Fleurie Nursery , Lake Lane.
Response to ADC Engineer questions.

For reference block names are as per drawing attached and abbreviations as shown in parenthesis are used throughout - southern tunnels (ST), southern glass (SG), eastern glass (E), northern (N).

Drawing #3. North area.
8.5m contour containment.
1:500

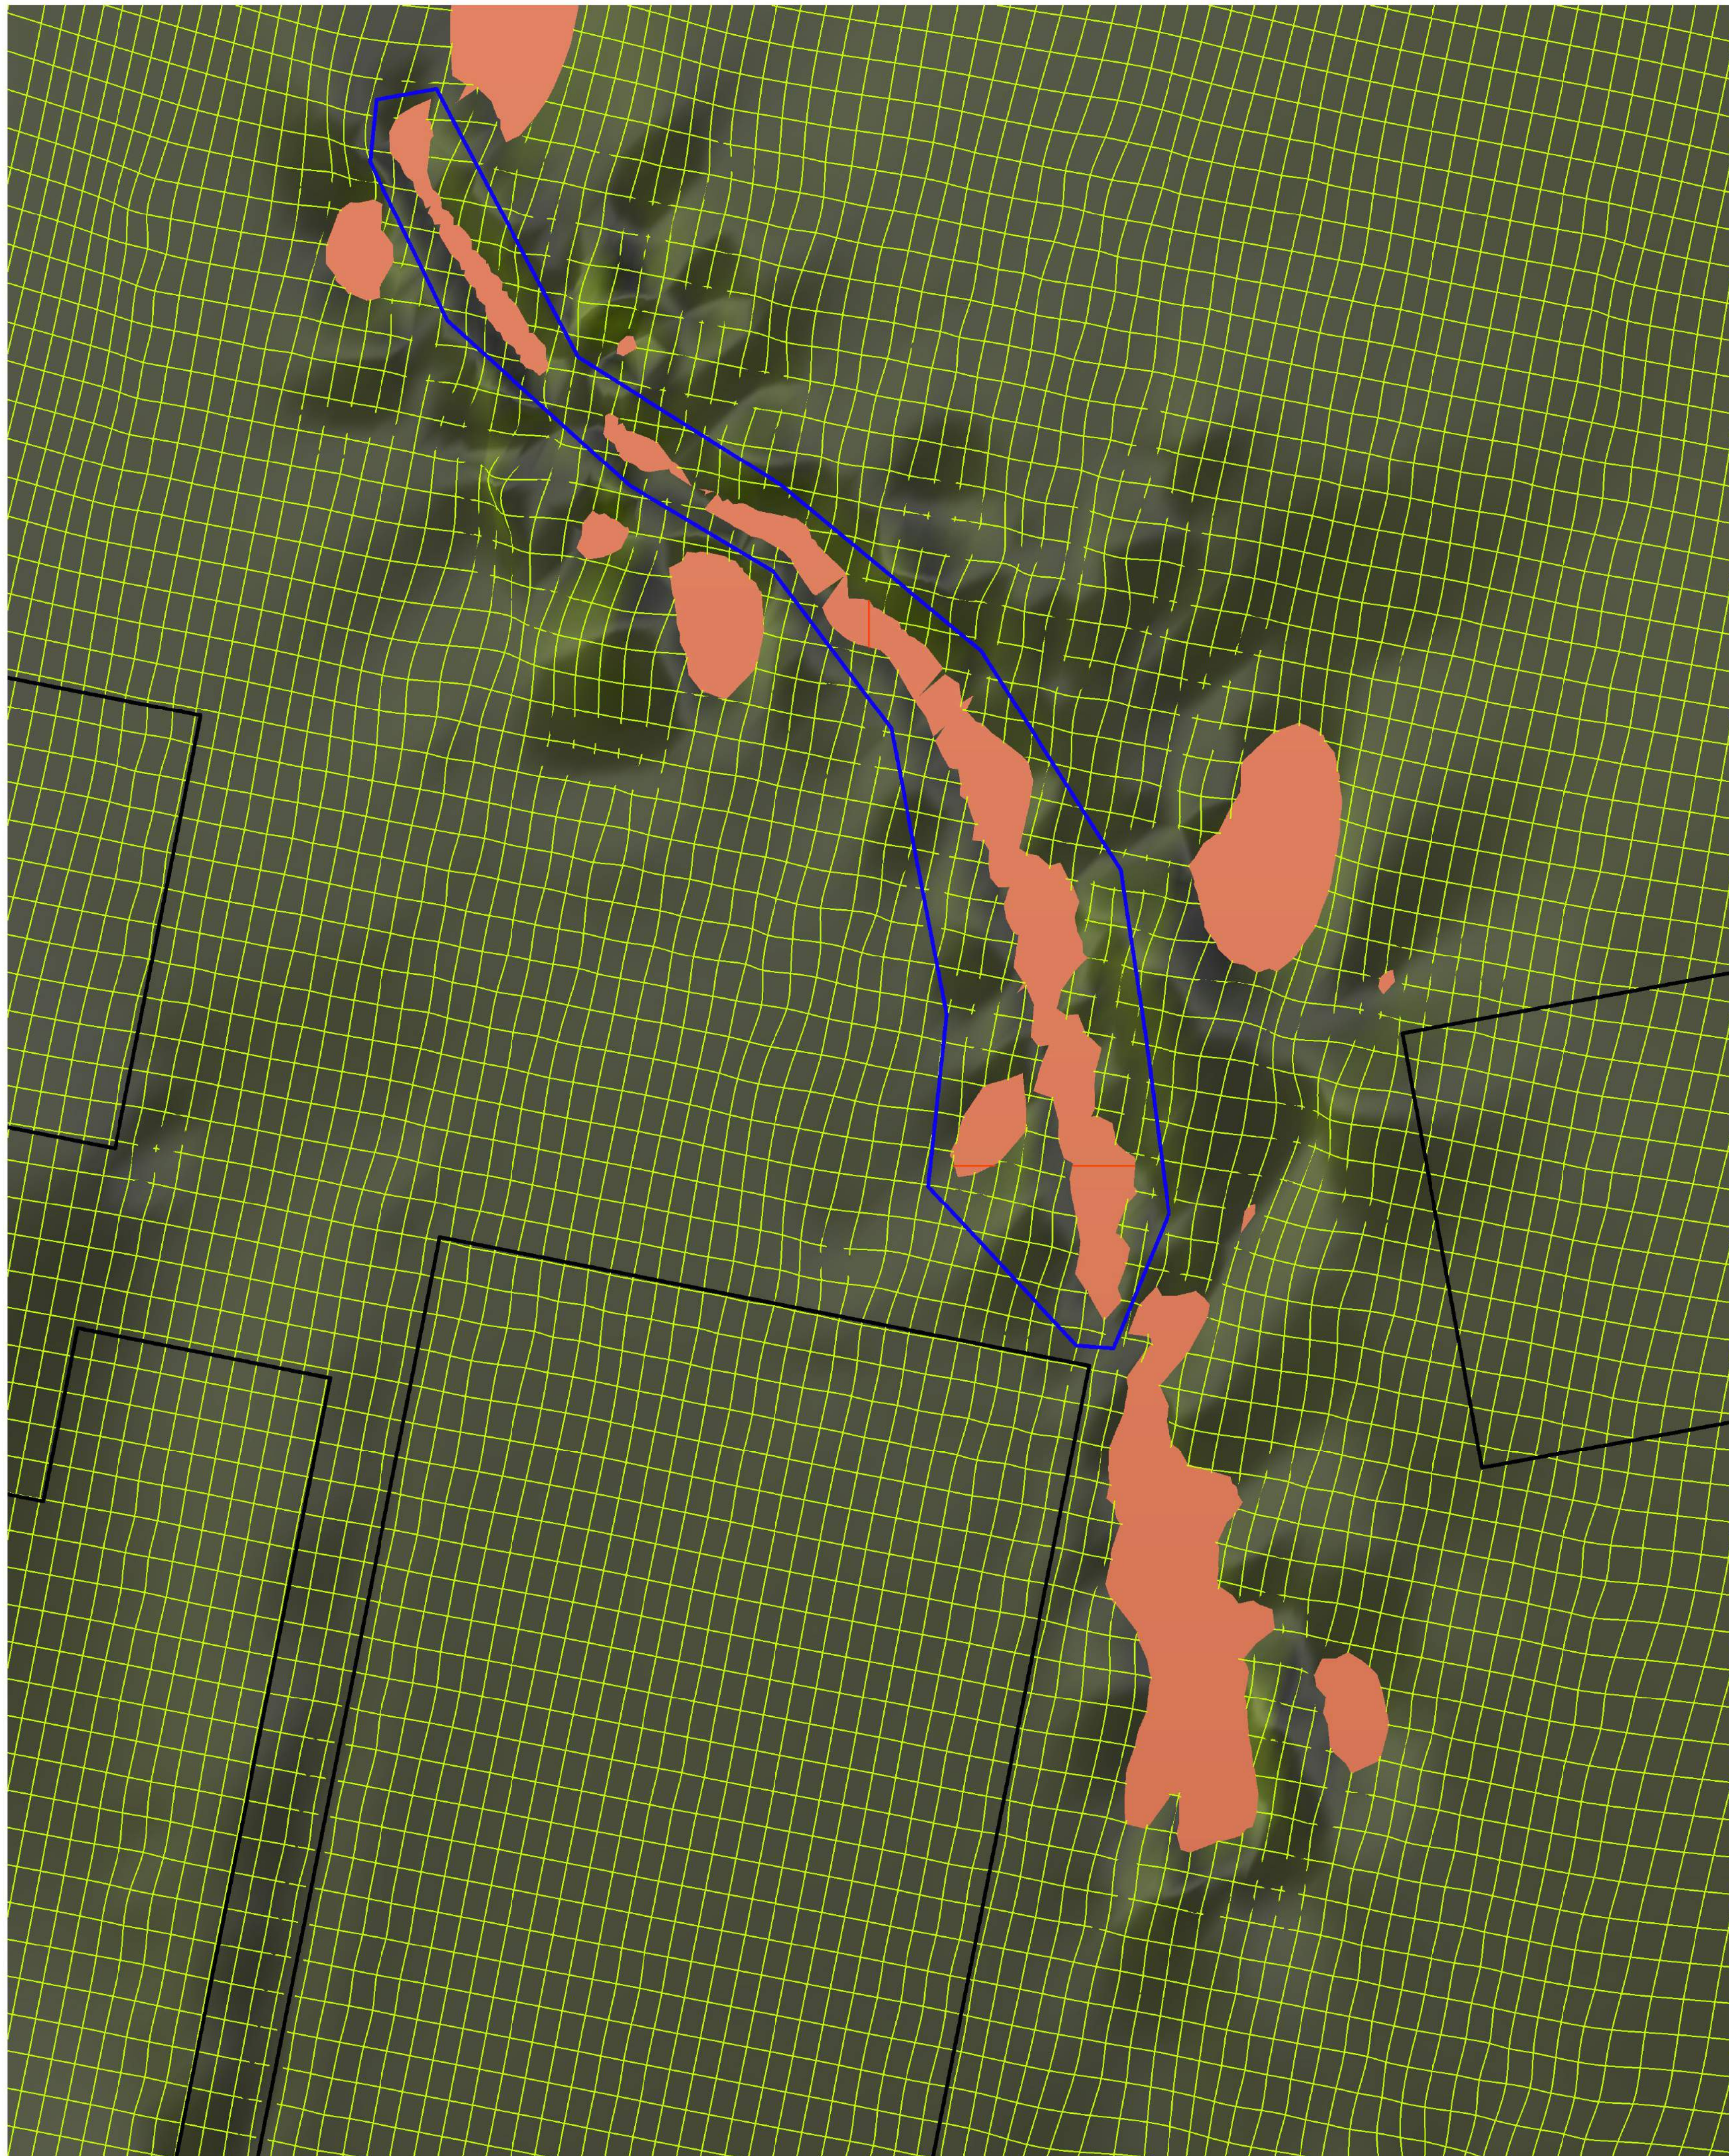
Northern area (NT and EG).

The following analysis is based on the topographical surveys on site, the last of which was undertaken in March 2023. Rhino 3D software was used to plot the topographical mesh and calculate volumes using a cutting plane.

The northern greenhouses are considered as a whole, and the largest tank is 369m³. There is a

naturally contained area here (see attached drawing #2), comprising the existing low land bordered by the raised areas for the greenhouses to the south, west and east, and the naturally rising land to the north. The watercourse is at the lowest point, in a well-defined, engineered (ie non-original), ditch, and under normal flow conditions varies in depth from 1.5 to 1.1m, and is typically around 6m wide from top of bank to top of bank, and around 1m at the base. There are 3 culverted sections shown – marked A, B and C. A and B form crossing points, and C is a longer section presumably installed as part of a site levelling for the greenhouses on the adjoining property. This latter one runs for a length of c. 70m, and is 12" diameter.

The volume contained at the 8.5m contour for the upper 2 sections of ditch including immediate low lying land is 467m³ (indicated by those pockets shown brown on Drawing #3, and the relevant ones included within the dark blue line). This therefore more than meets the exceedance requirements.

Non SE orifice plate
discharge details
(North, East, SW).

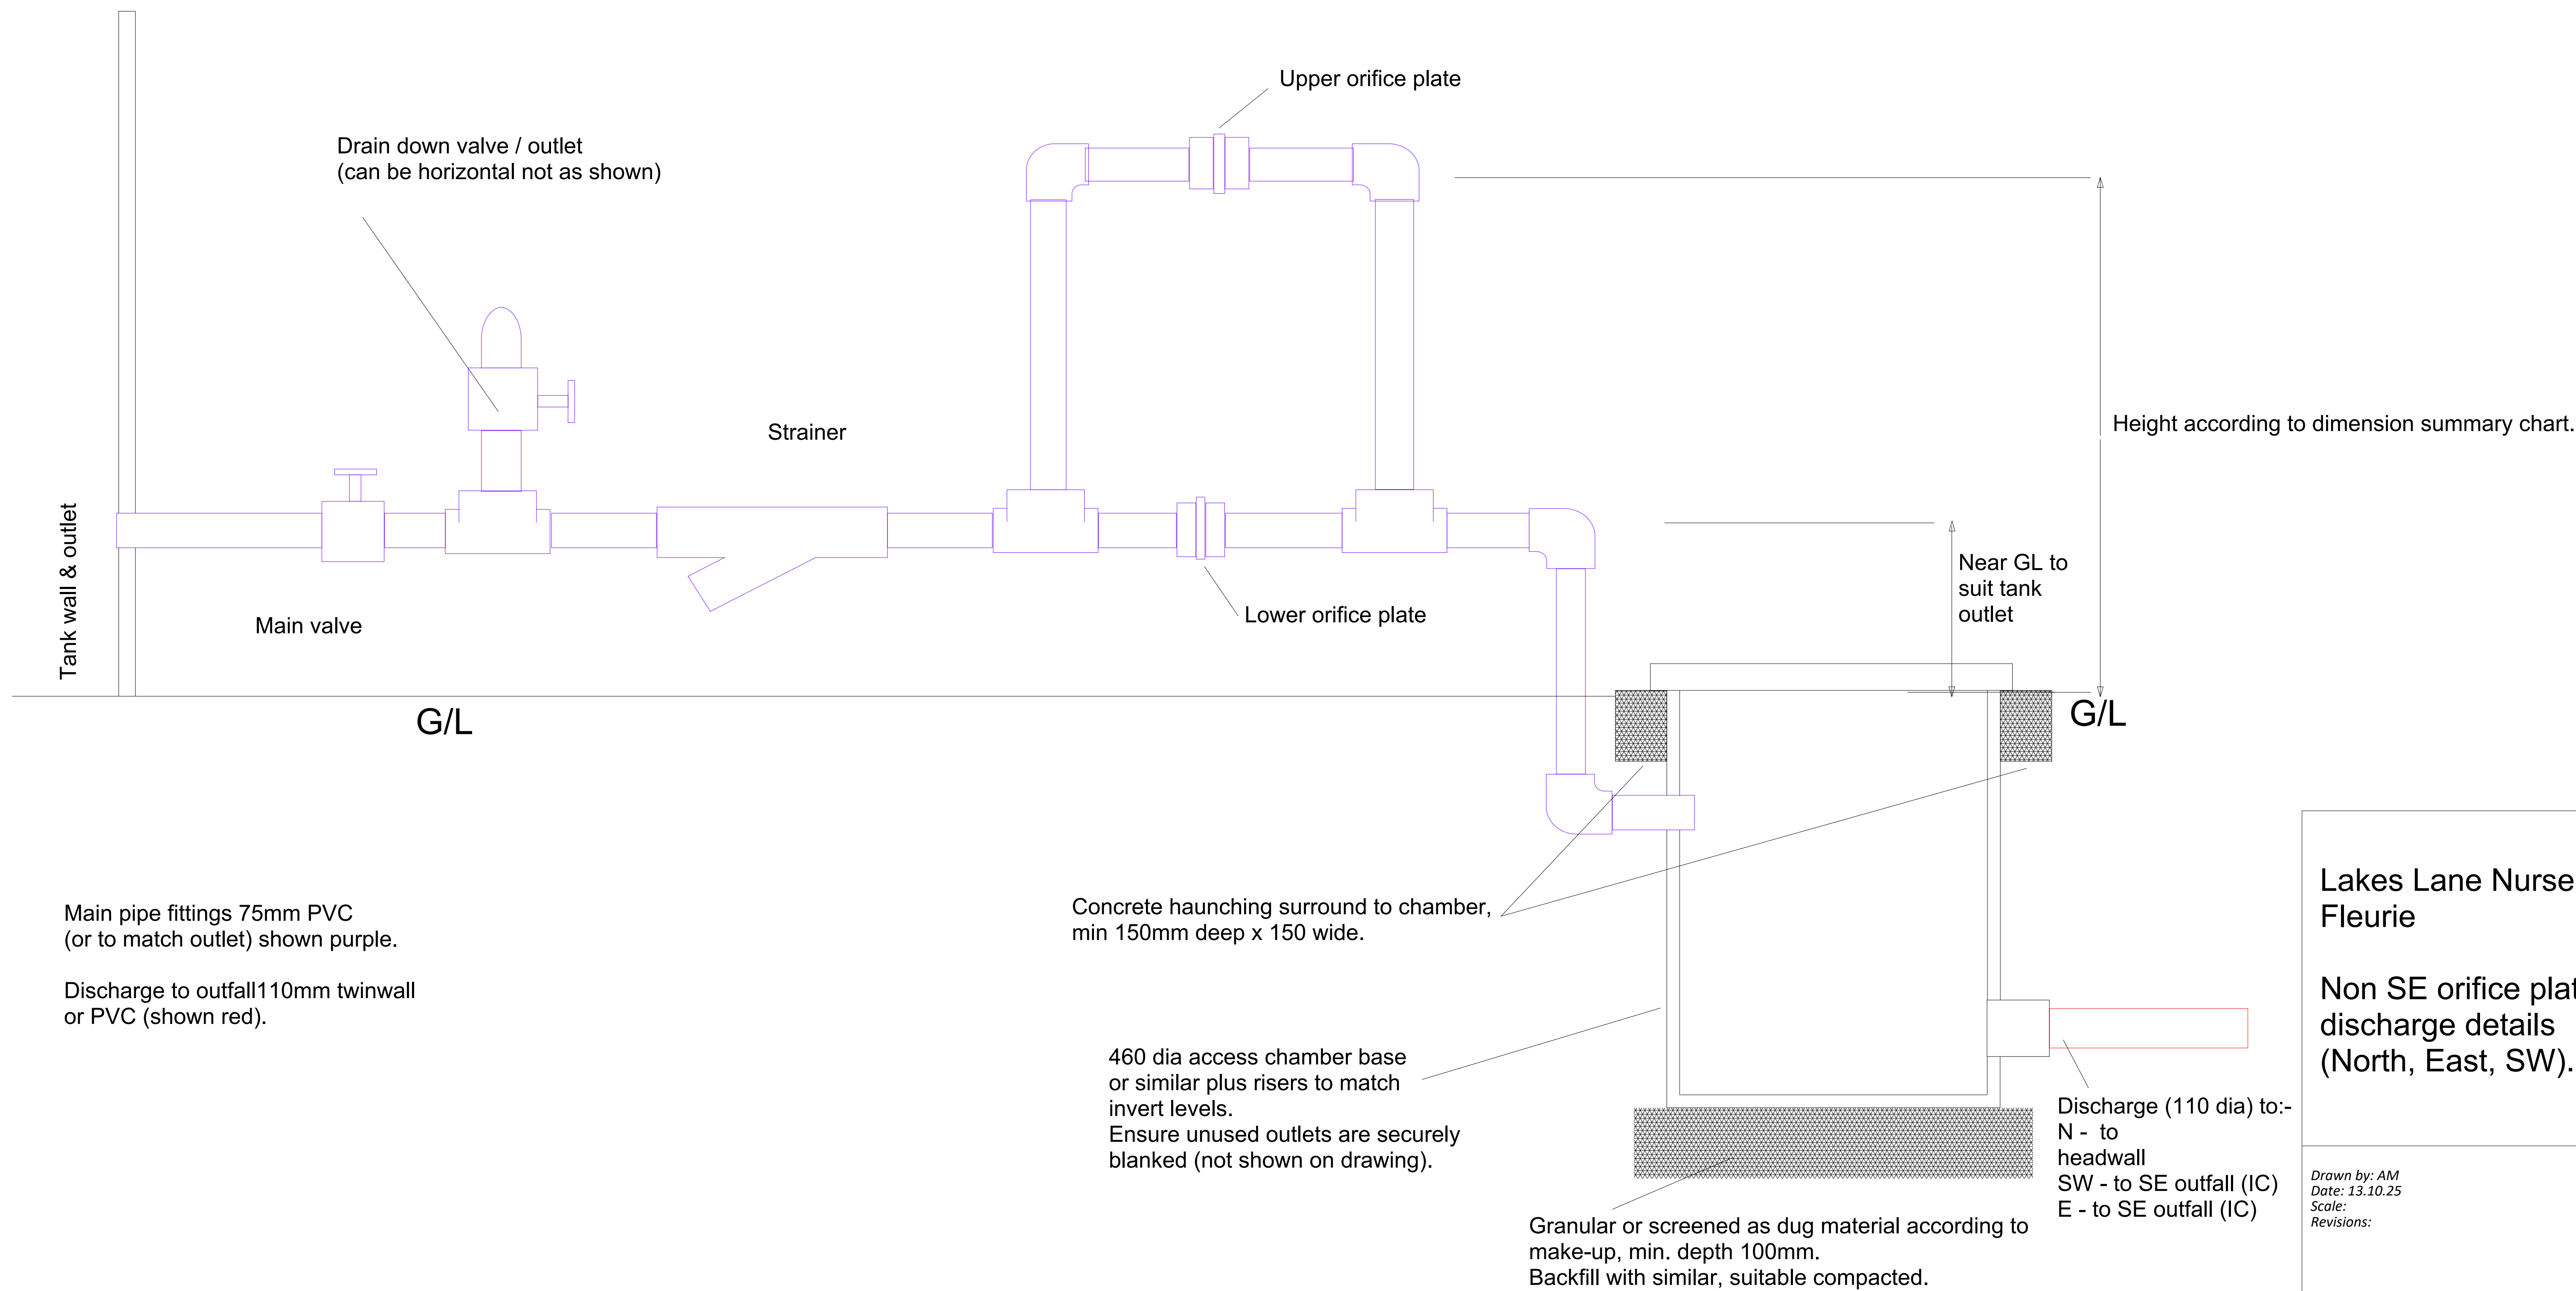
5b. Protection against fouling of orifice plates

In-line coarse filter (2,500 micron) to be installed upstream of lower orifice plates. Upper orifice plates are larger diameter, and employed very infrequently, and due to their upper location are far less likely to be impacted anyway. It is therefore deemed prudent to leave this upper orifice plate without filtration.
